WEST SUSSEX COUNTY COUNCIL CONSULTATION

TO:	Arun District Council FAO: Simon Davis
FROM:	WSCC – Lead Local Flood Authority
DATE:	24 th March 2021
LOCATION:	Land At Wings Nursery Lidsey Road Woodgate PO20 3SU
SUBJECT:	AL/20/21/PL Demolition of Wings House & erection of 71 No. replacement dwellings (70 net new dwellings), access arrangements, sustainable drainage measures, public open space, landscaping & all other associated works (resubmission following AL/46/20/PL). This application is a Departure from the Development Plan
RECOMMENDATION:	Advice - No Objection

DRAINAGE STRATEGY

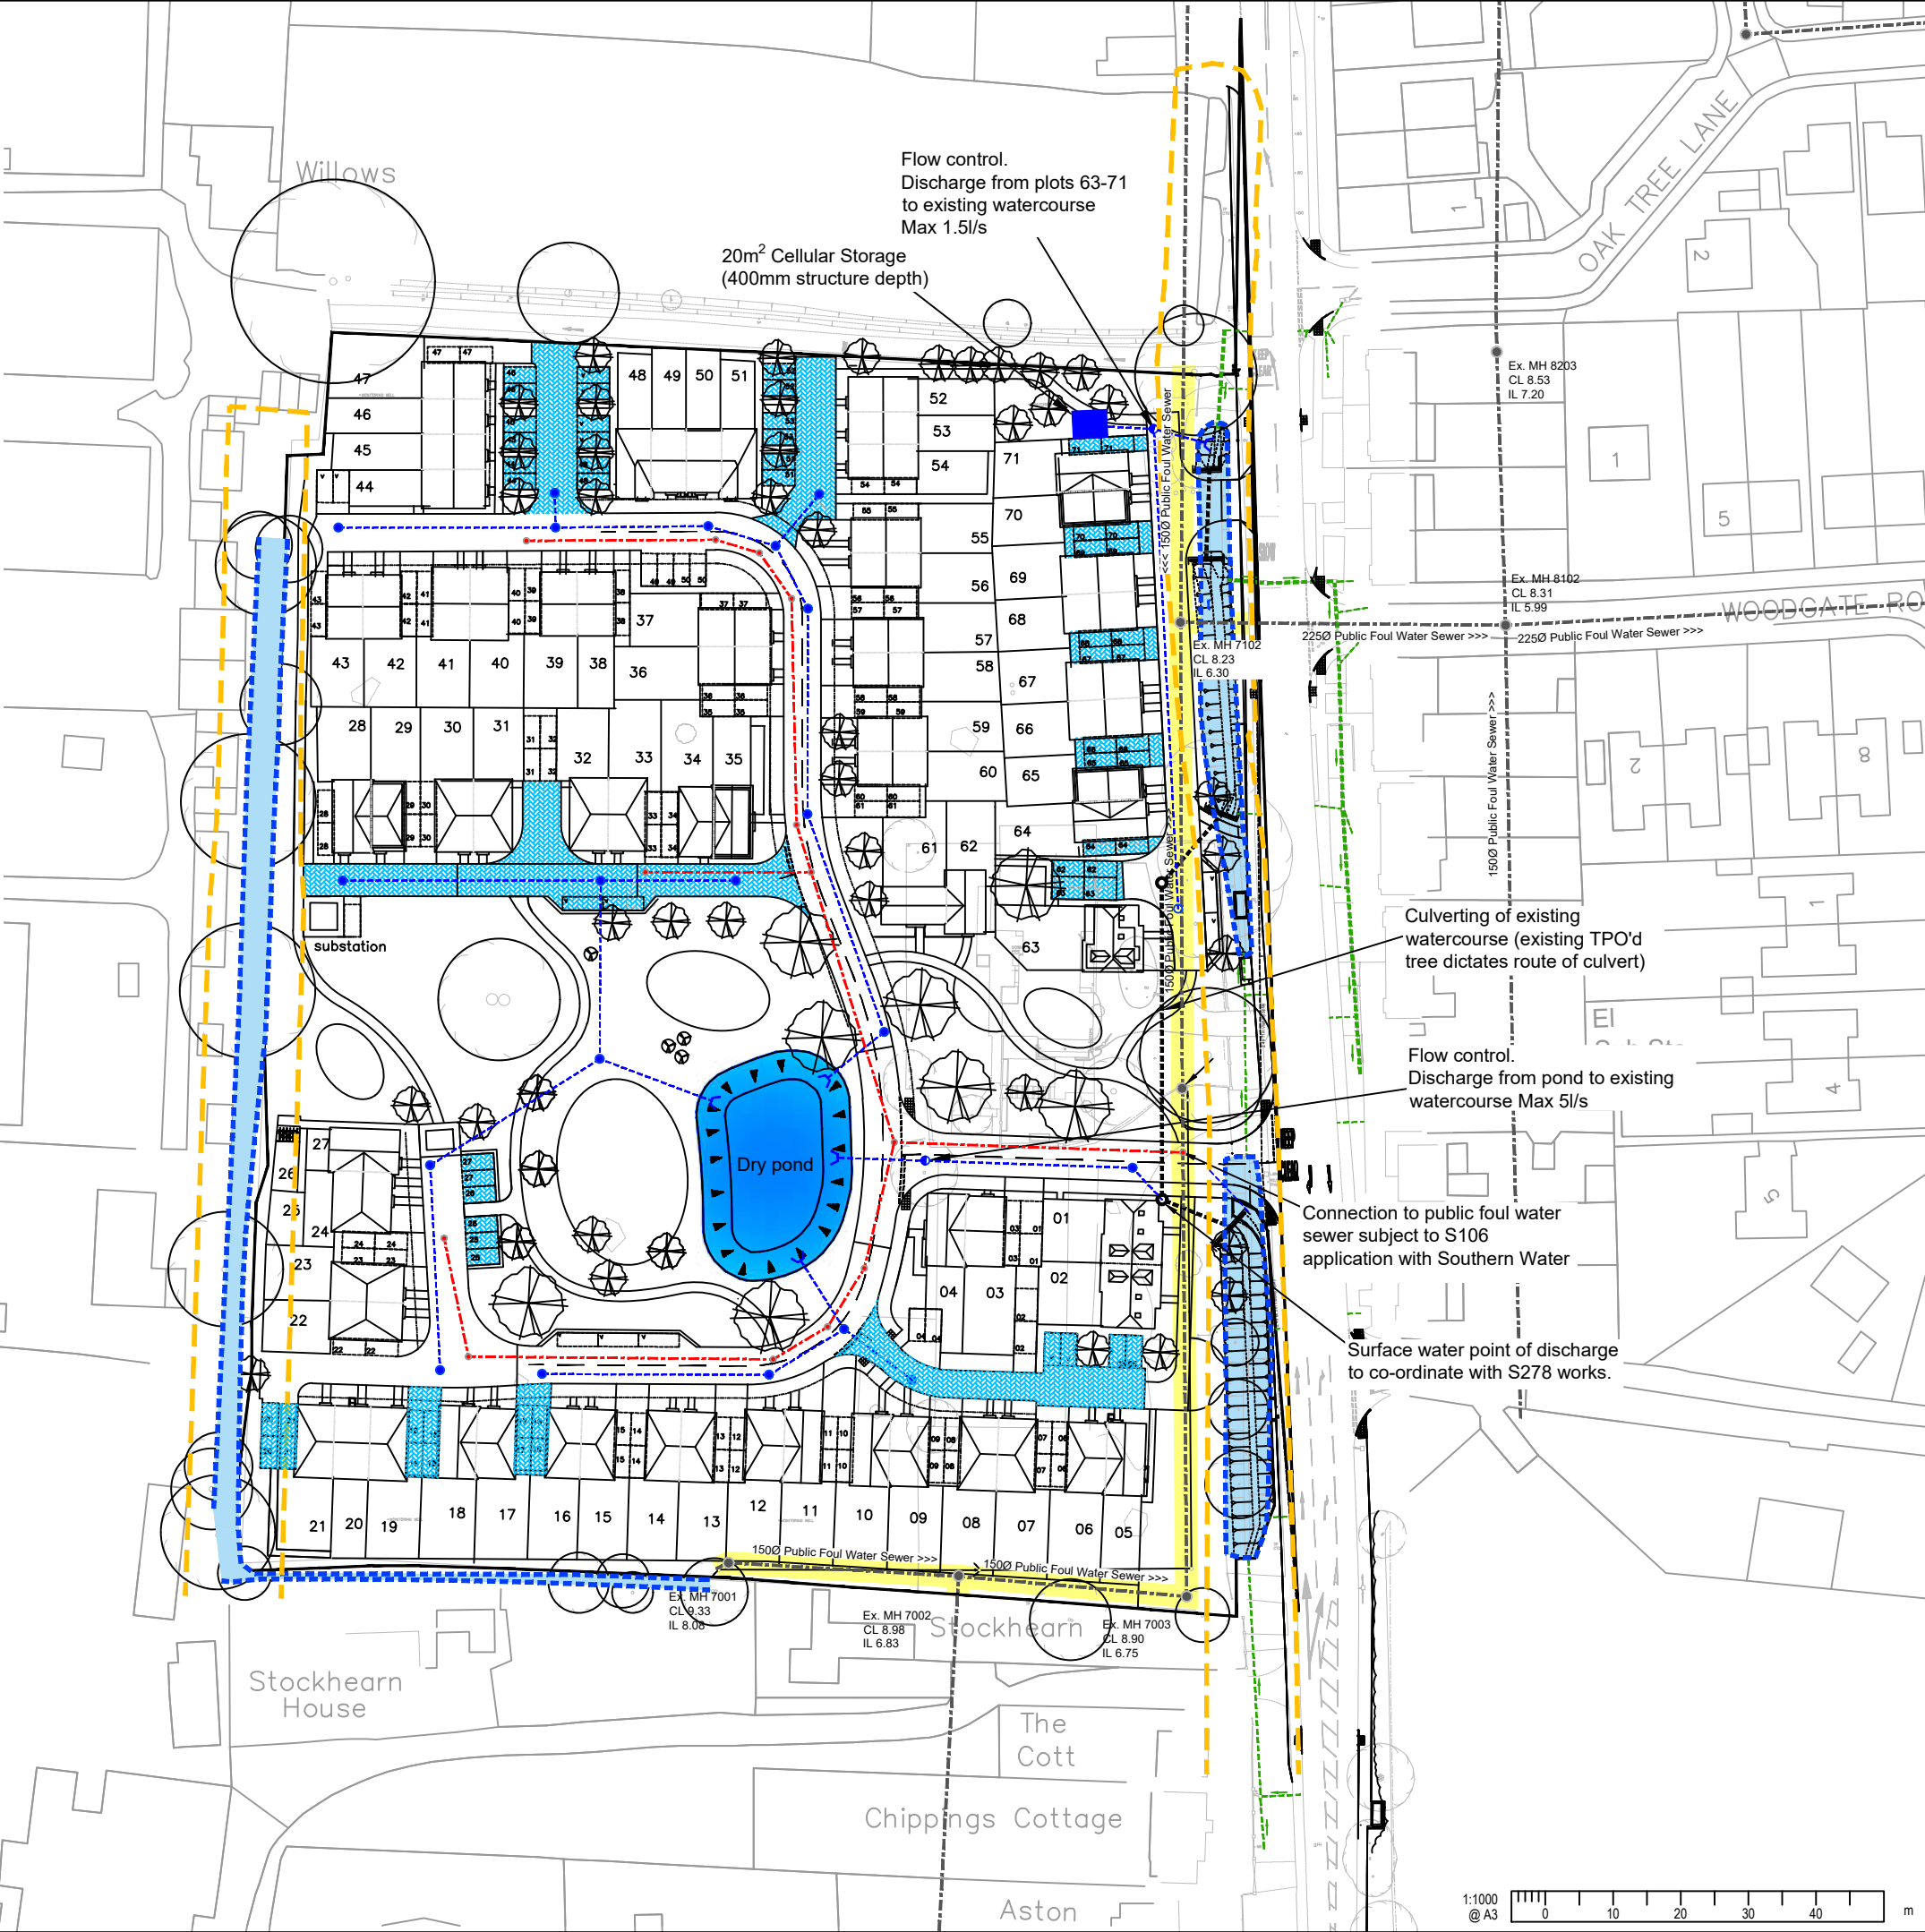
Concerns were raised, by the District Drainage Engineer, on previous applications on this site than an appropriate buffer was not included alongside the western watercourse as well as further clarification regarding extent of the local ditch system. This is still unclear whether these investigations have been done/amendments made.
